# Memorandum

**SUBJECT:** MODIFICATION APPLICATION FOR RESOURCE RECOVERY  
FACILITY AT 35-37 FRANK STREET, WETHERILL PARK

**FILE:** SSD 7256 MOD 3

**DATE:** 30 APRIL 2019

DRAWING TITLE
SITE PLAN DETAIL-PART 1

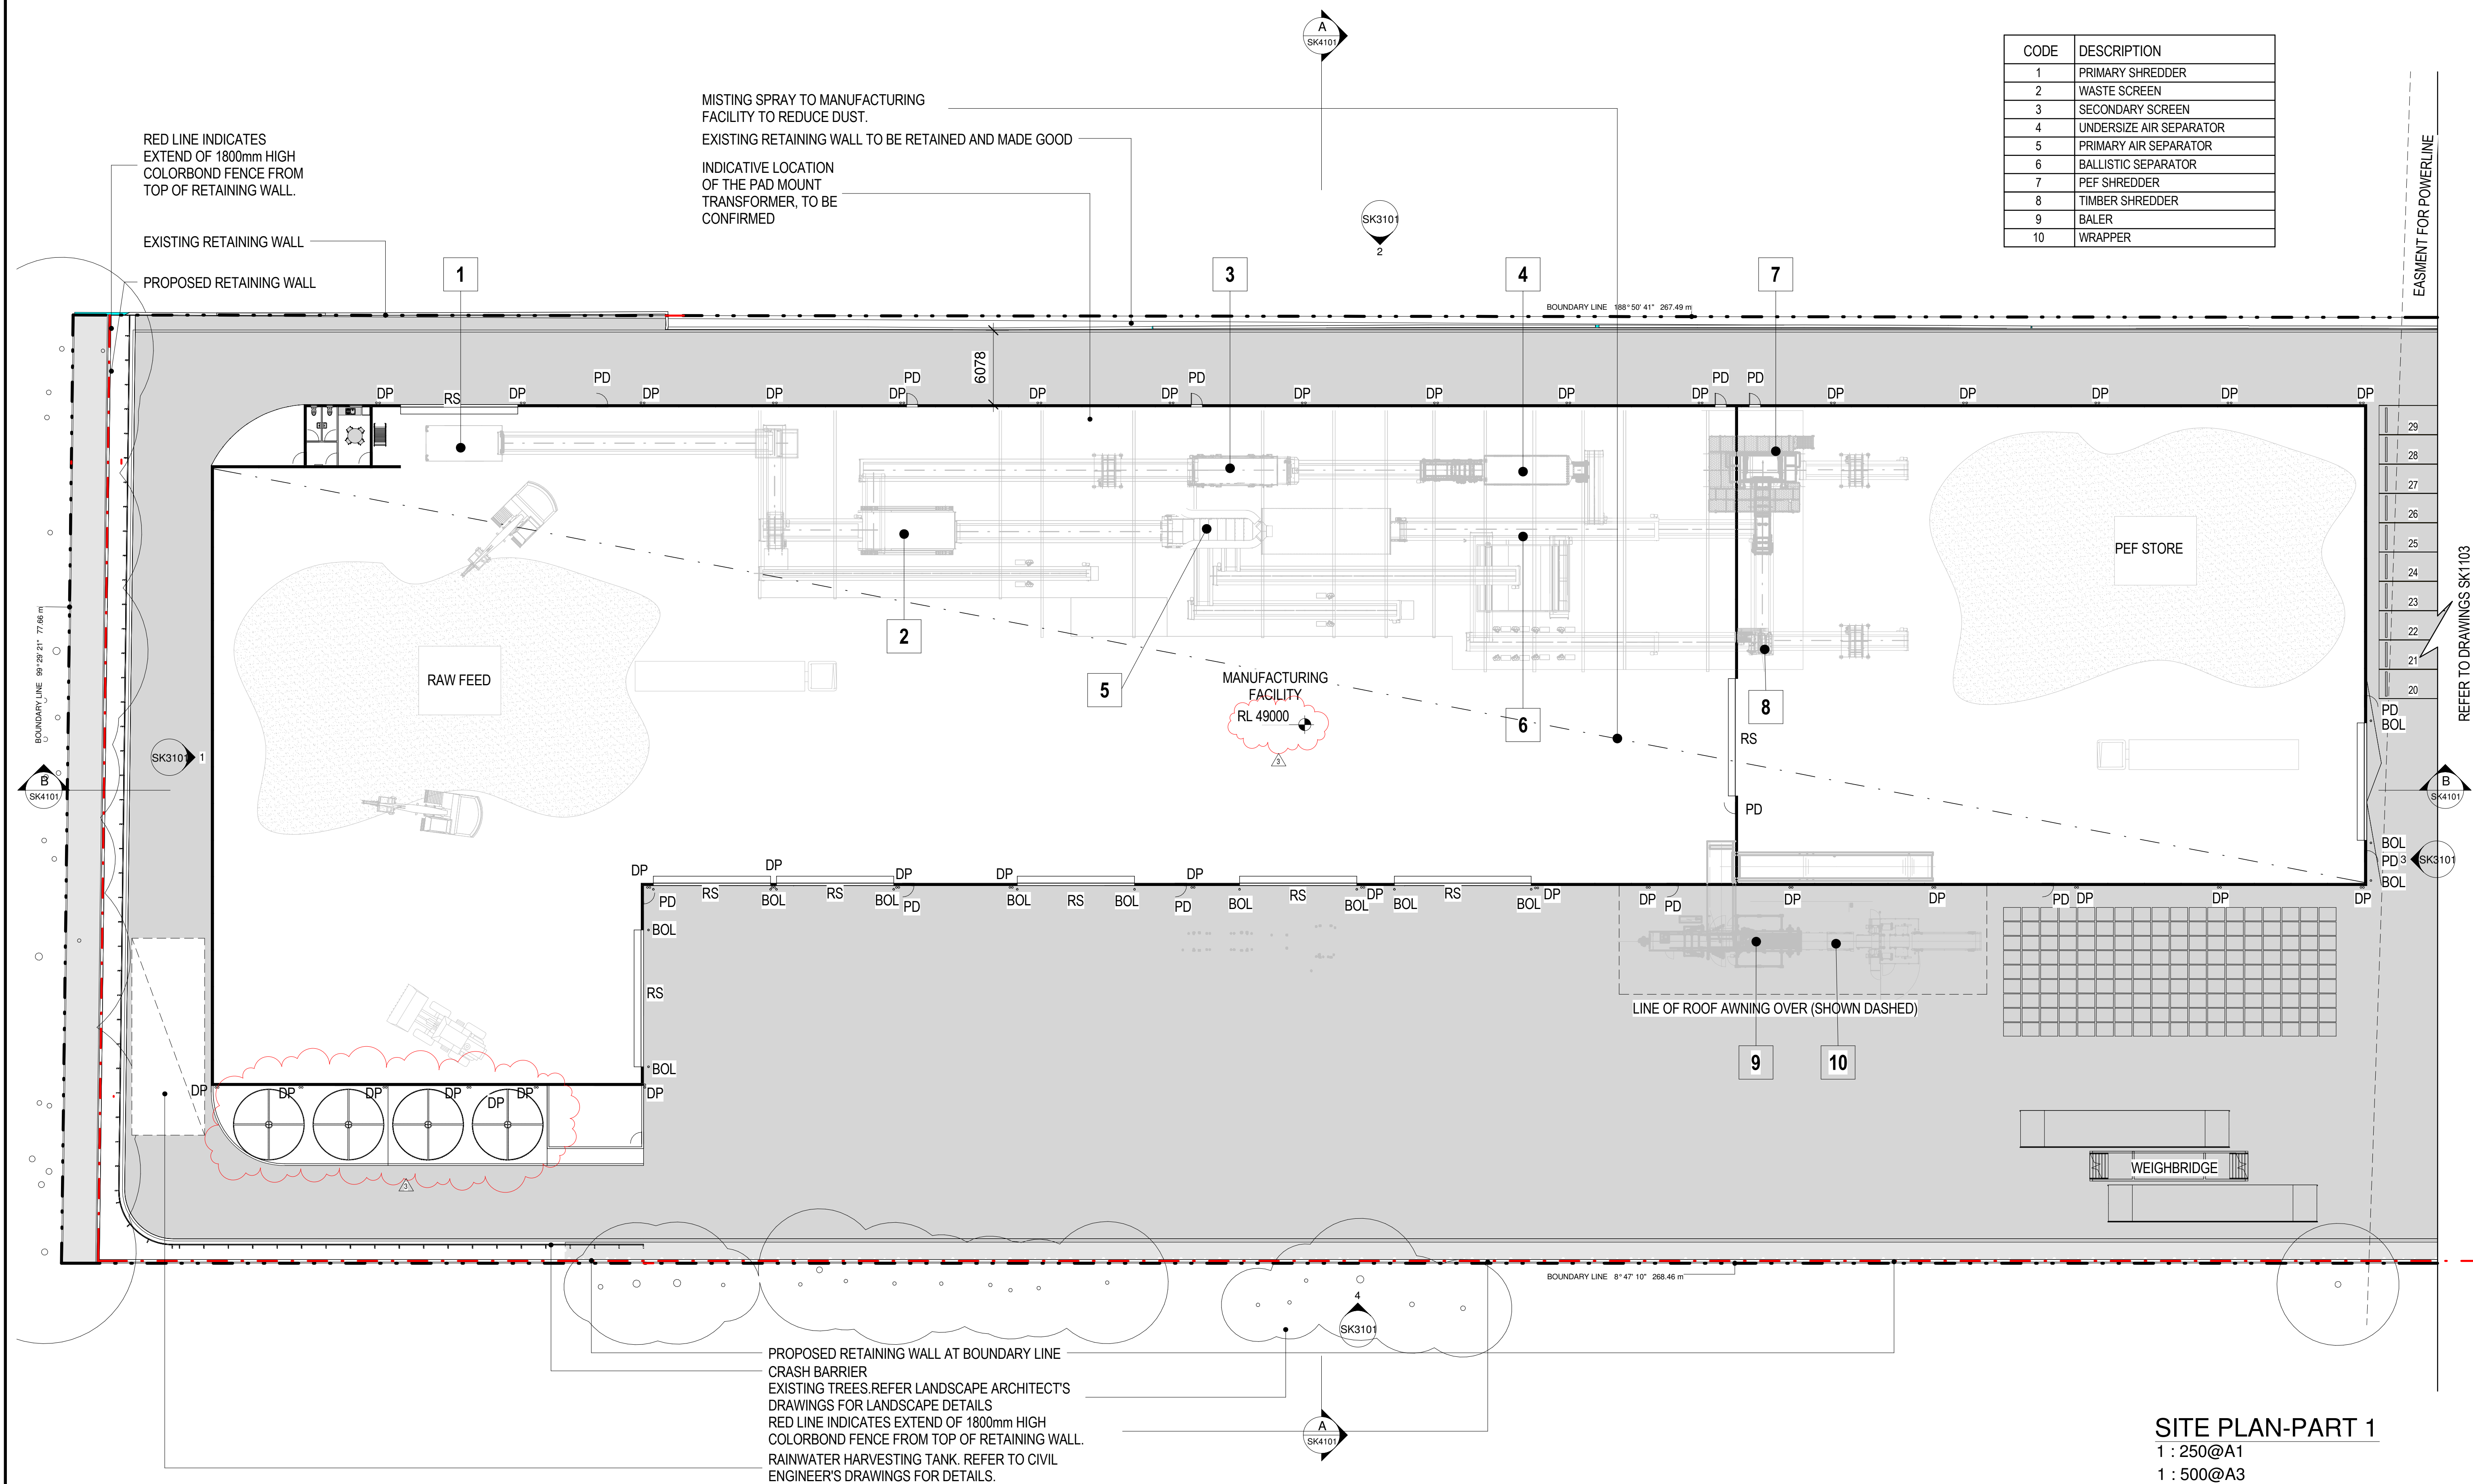
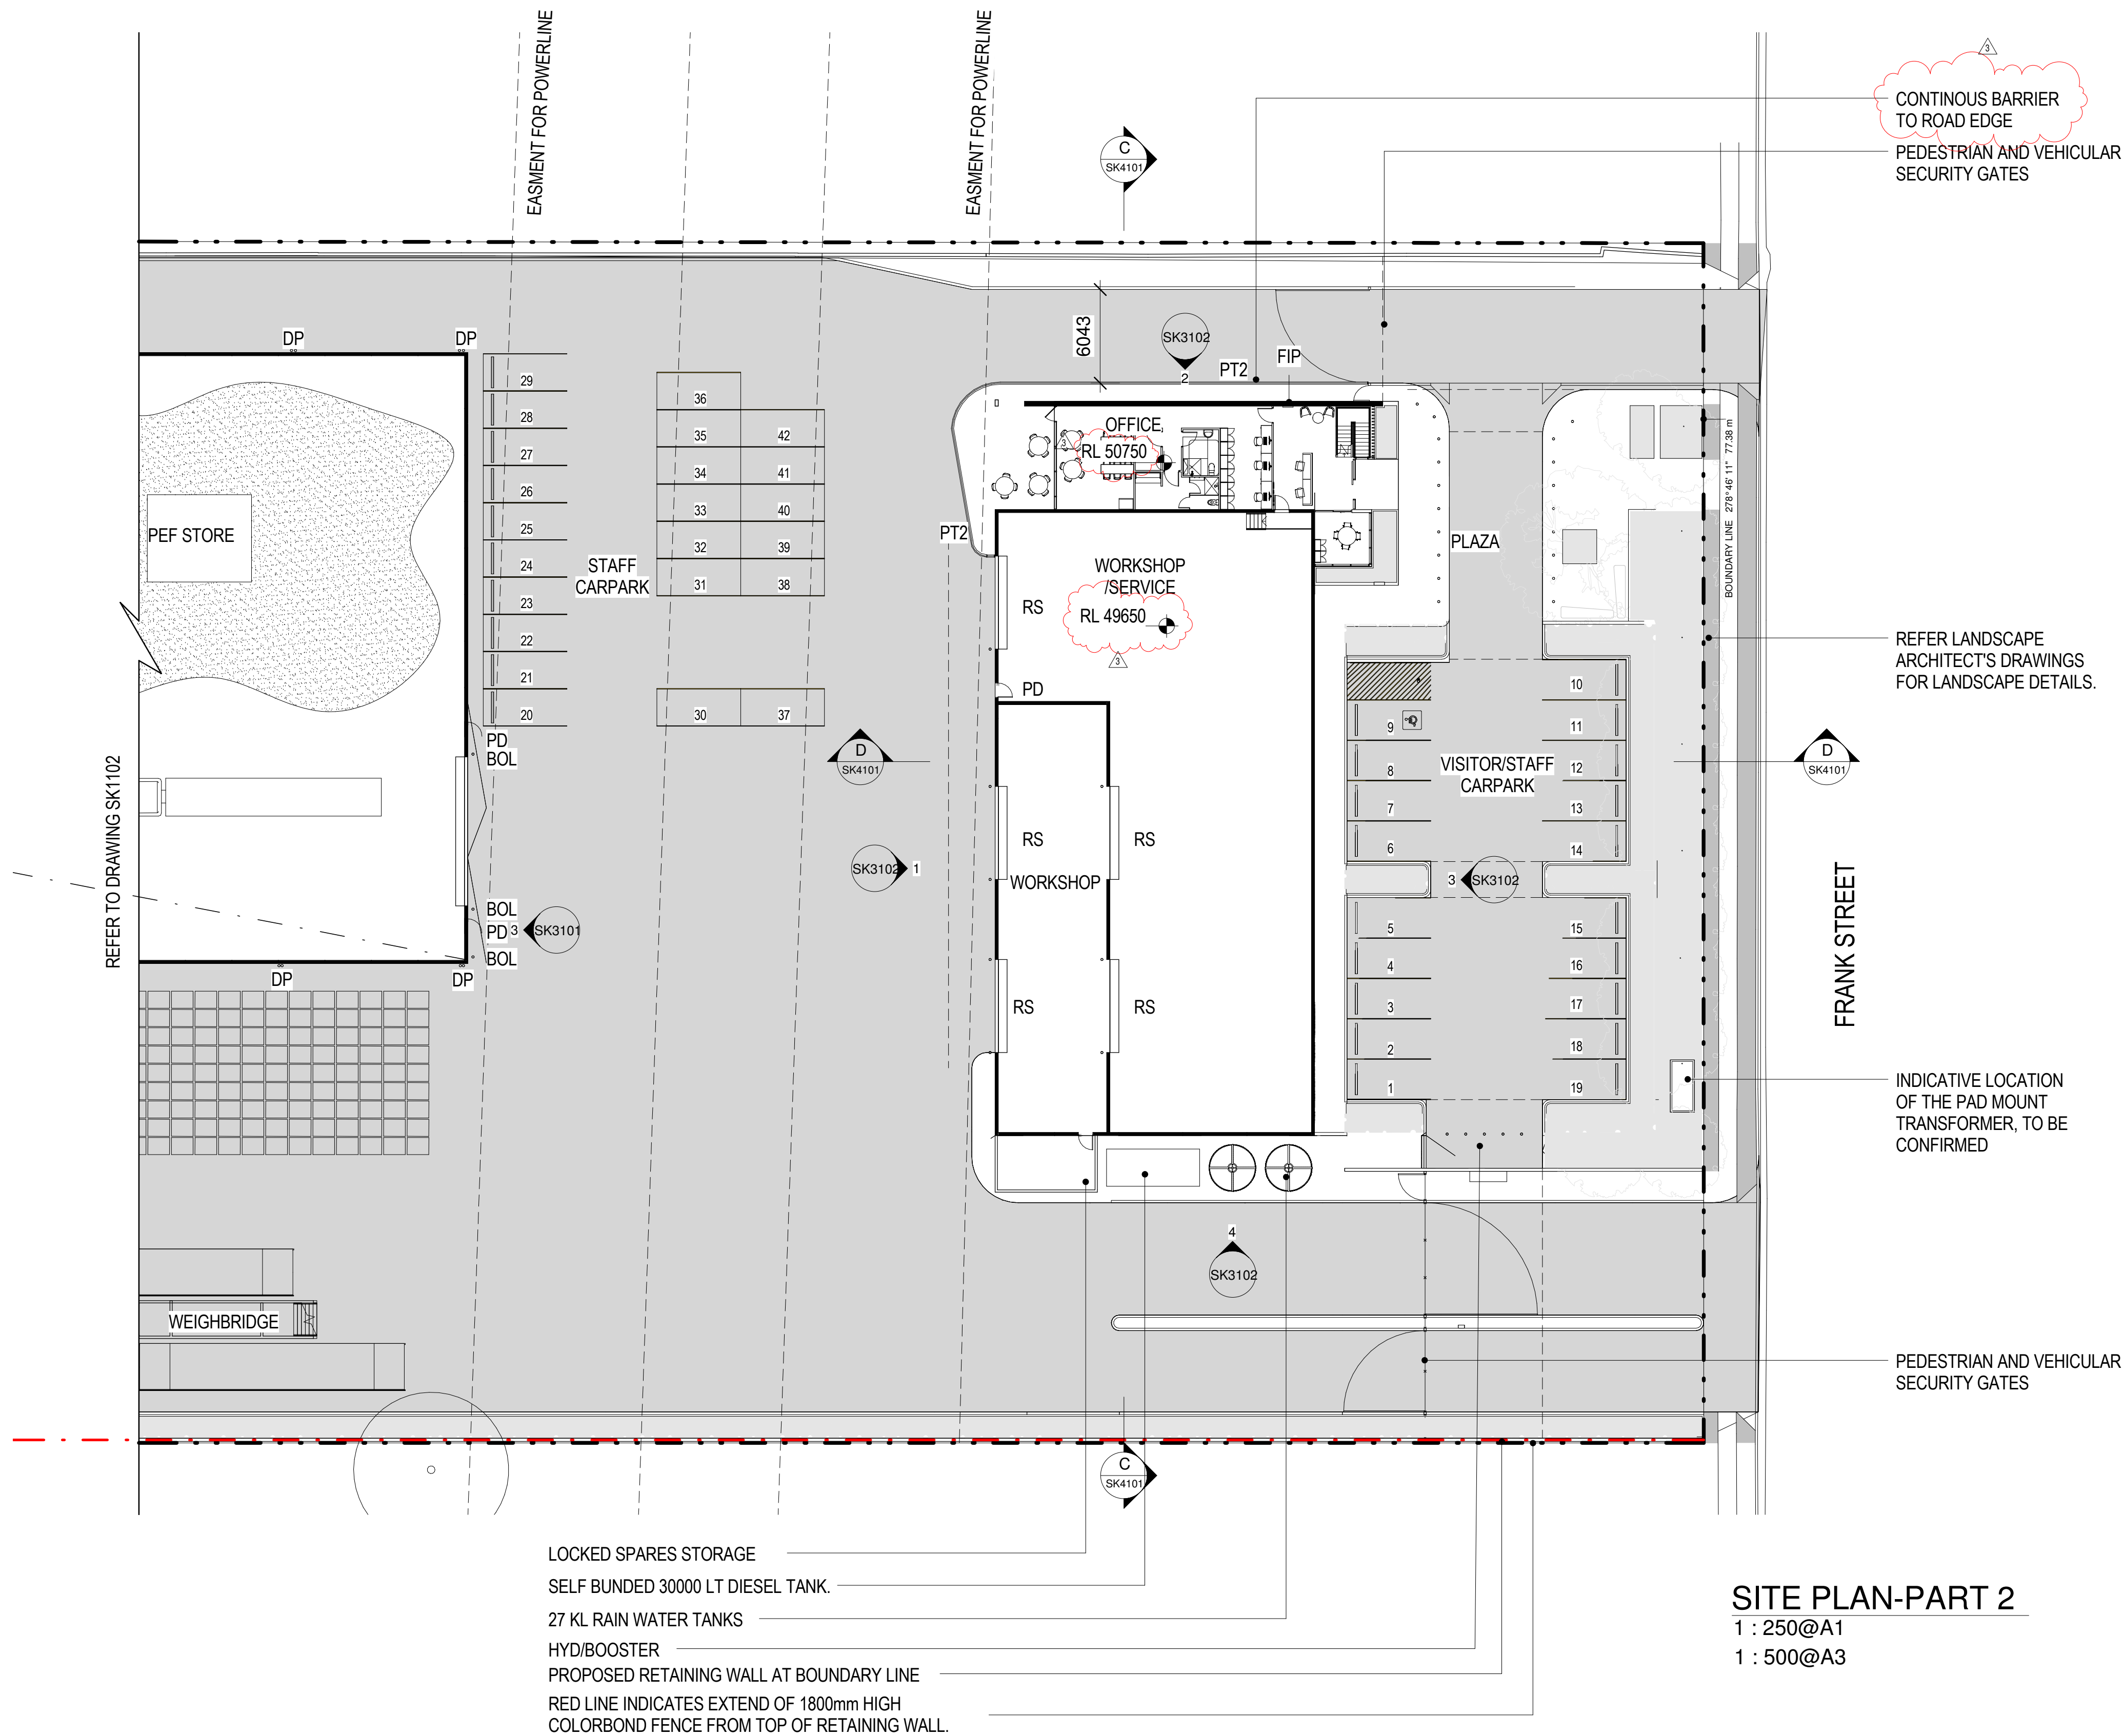
The modification seeks to replace the approved designated storage area wrapped and baled process engineered fuel (PEF) to the existing an outdoor storage area from 287m<sup>2</sup> to 1,291m<sup>2</sup>.

The proposal involves 4 fold increases in the designated area for external storage of processed, wrapped and baled Processed Engineered Fuel (PEF). It states that as all materials are sealed, any potential leachate or litter issues can be managed by existing stormwater quality control devices. It is noted that these devices are gross pollutant trapping devices and do not treat leachate. Discussions with the EPA reveal ongoing issues with containment of existing outdoor storage, including loss of containment of baled waste.

No details of any fire fighting water retention system for outdoor areas have been presented or, if one exists, the implications the 4 fold increase in materials stored onsite. A fire engineering report dated 2017 refers to containment of fire fighting water 'within the footprint of the building'. This is not relevant to outdoor storage.

- Either
  - Details of the containment and disposal of leachate from the outdoor storage of Processed Engineered Fuel (PEF); or
  - Details of internal storage of Processed Engineered Fuel (PEF);
- Details of the onsite containment of fire fighting water.

A review of the plans reveal that the storage area at the site shall be differentiated from the manoeuvring/circulation areas by signposting and line markings.
